Ribble Valley Borough Council
Development Control
Council Offices Church Walk
Clitheroe
Lancashire
BB7 2RA

Our ref: NO/2014/106817/01-L01
Your ref: 3/2014/0597
Date: 31 July 2014

OUTLINE APPLICATION FOR UP TO 275 NEW DWELLINGS AND ACCESS. ALL OTHER MATTERS RESERVED (RE-SUBMISSION OF 3/2012/0913: OUTLINE APPLICATION FOR A RESIDENTIAL DEVELOPMENT AND A CRECHE)

LAND OFF WADDINGTON ROAD, CLITHEROE, LANCASHIRE, BB7 2DE

Drawing Number  
**1110.1**

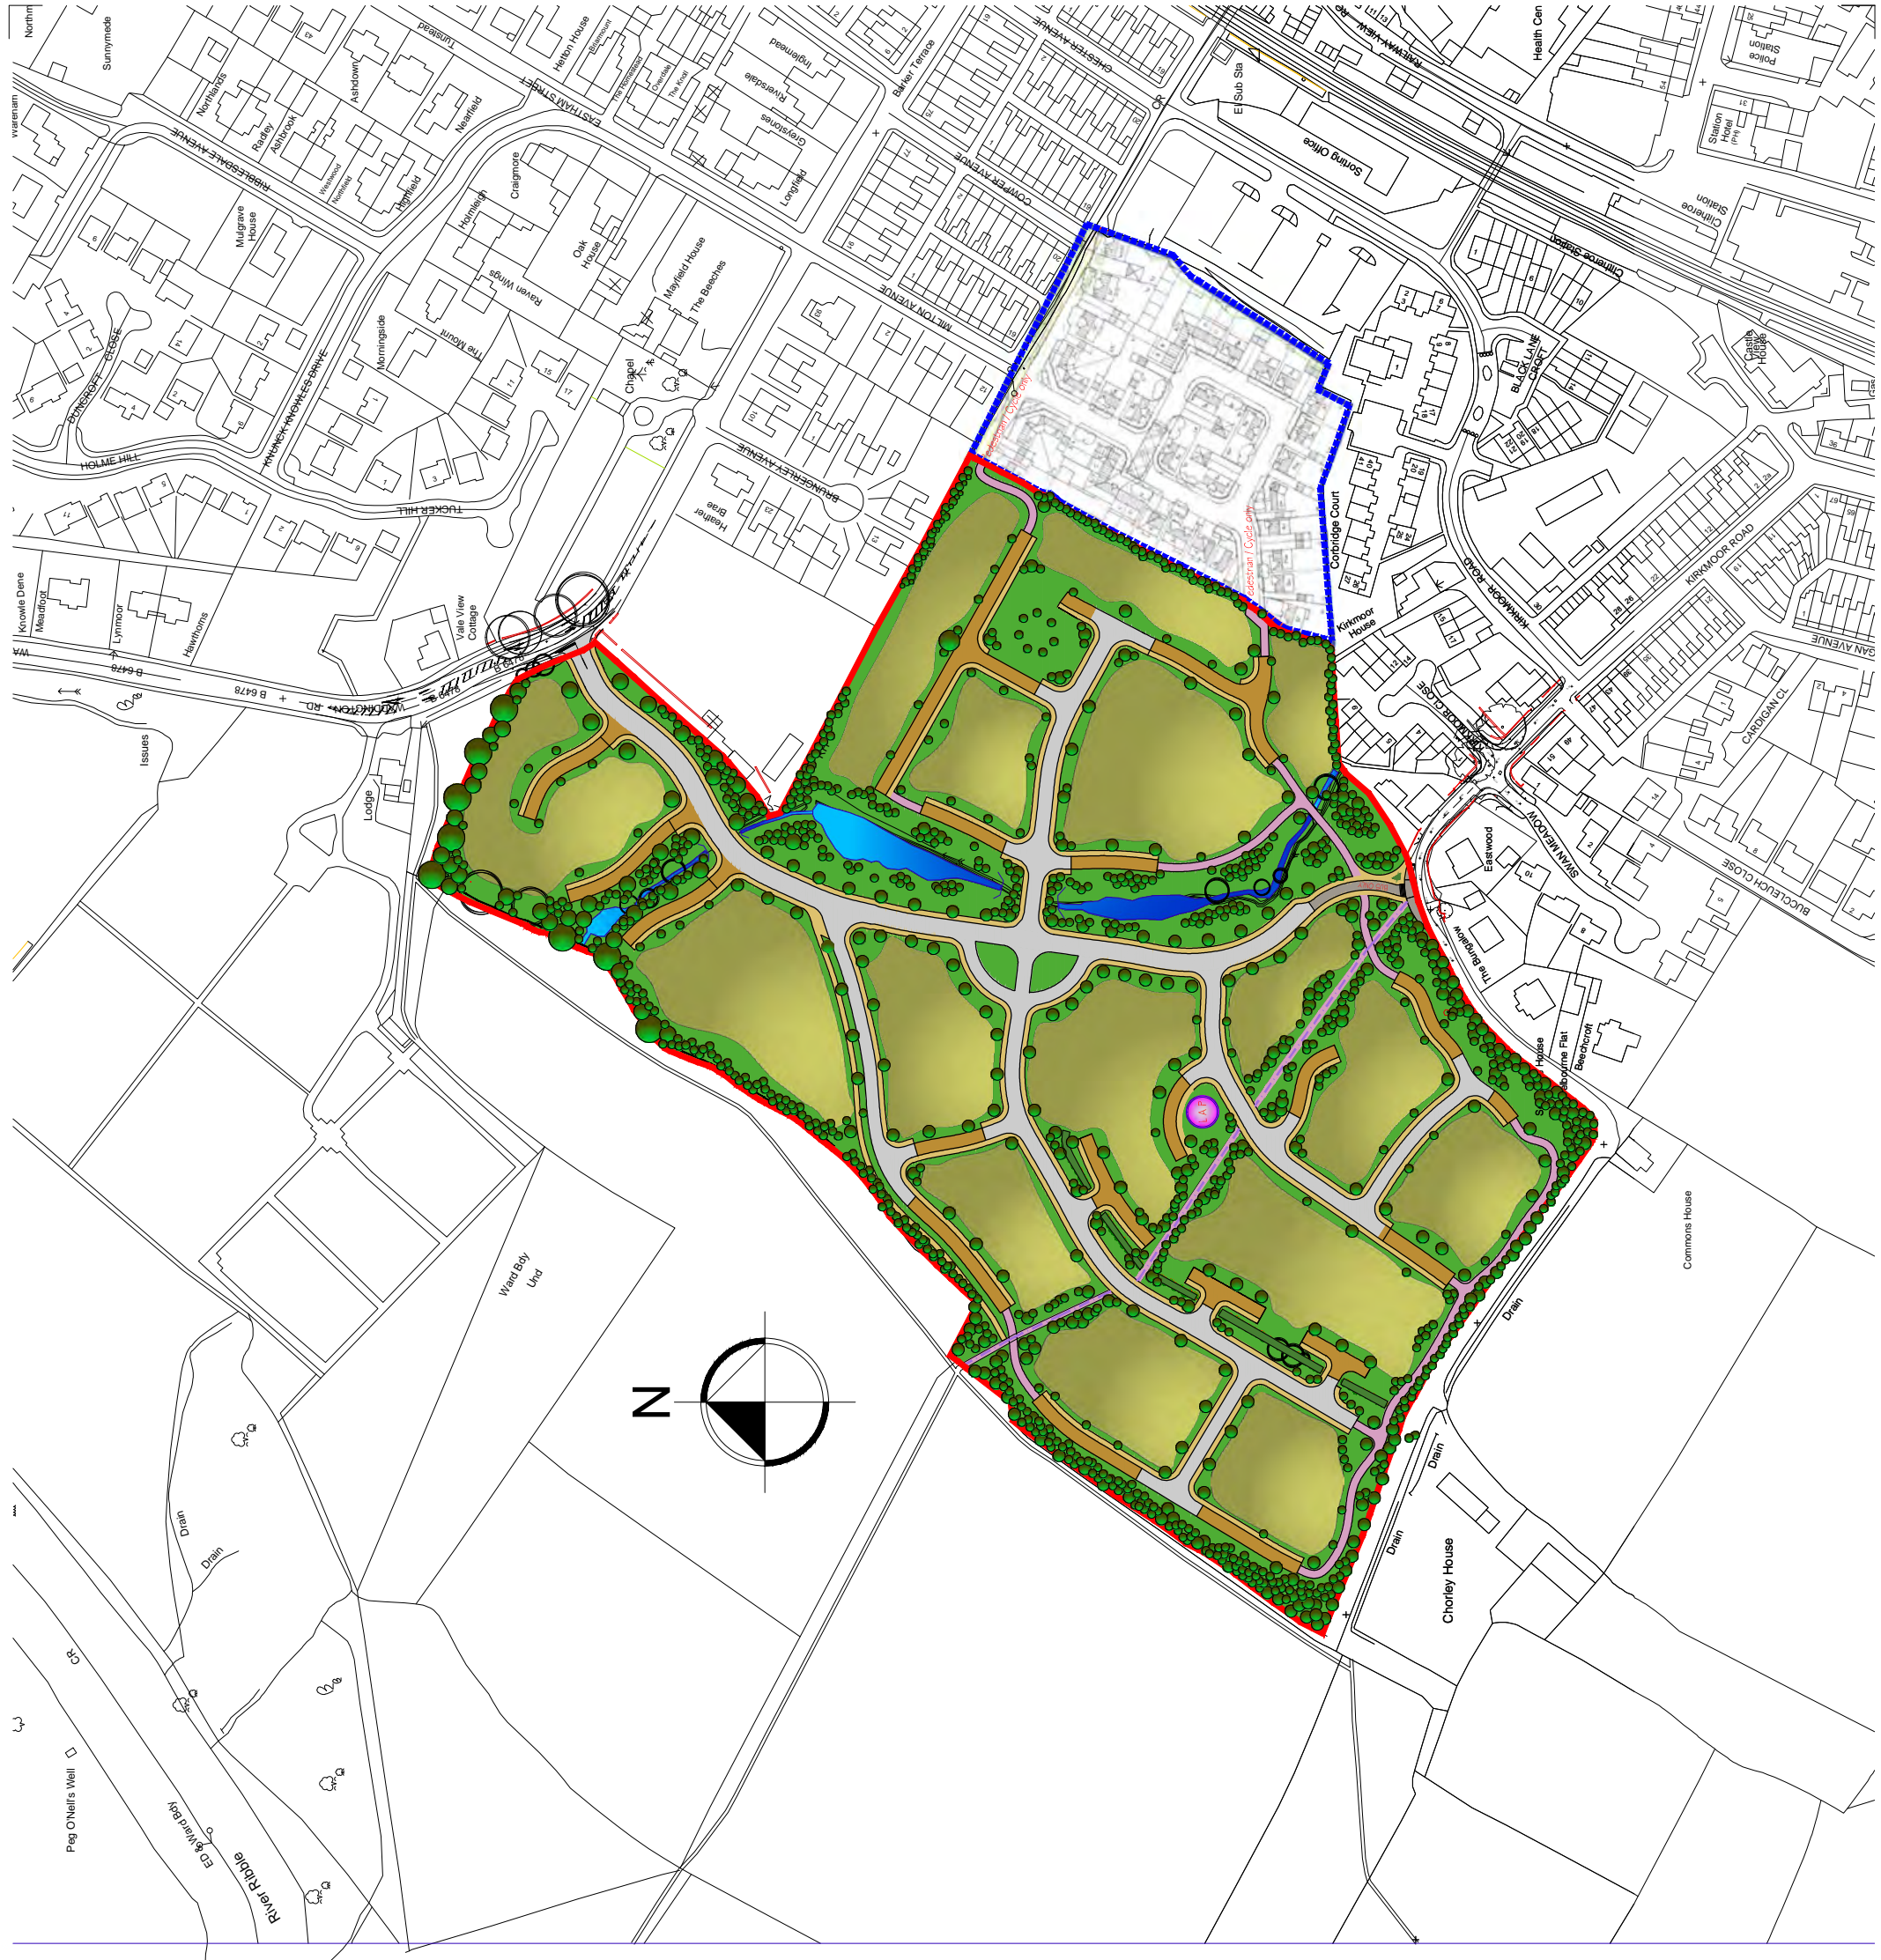
We support the retention and enhancement of the riparian corridor bisecting the development site. However, the illustrative masterplan (Ref: 1110.1 Rev B) indicates that there may be online water features proposed on this watercourse. We advise against the creation of online water features, such as lakes and ponds, on the line of a watercourse, as they can interrupt the continuity of the river environment and restrict colonisation and drift by the aquatic fauna. The ecology becomes more lake-like and there is increased siltation. We also have experience of online ponds being stocked with non-native fish species which can have a detrimental effect by migrating into the wider

aquatic environment. Ponds with ditch or stream inflows have higher pollutant levels, significantly fewer plant and animal species, and many more management problems than other pond types. Stream-fed ponds also fill up much more quickly; often they fill completely within a decade or two. We therefore advise that water features should be created off-line. If pollution incidents or problematic algal blooms occur in off-line features there is little danger that they will affect local watercourses. Furthermore, excessive weed growth in an off-line feature can be treated with herbicides or by physical means without affecting local watercourses.

The illustrative masterplan (Ref: 1110.1 Rev B) also indicates that several roads and a footpath cross the watercourse bisecting the site. Where practicable, we recommend that watercourses are crossed by bridges rather than culverts. Bridges should be clear-span with the abutments set back from the watercourse on the bank tops and allow for a margin of bank 4 metres wide underneath, so as to maintain a continuous buffer strip and not interrupt the continuity of the riparian corridor, and reduce the risk of any pollution from run-off.
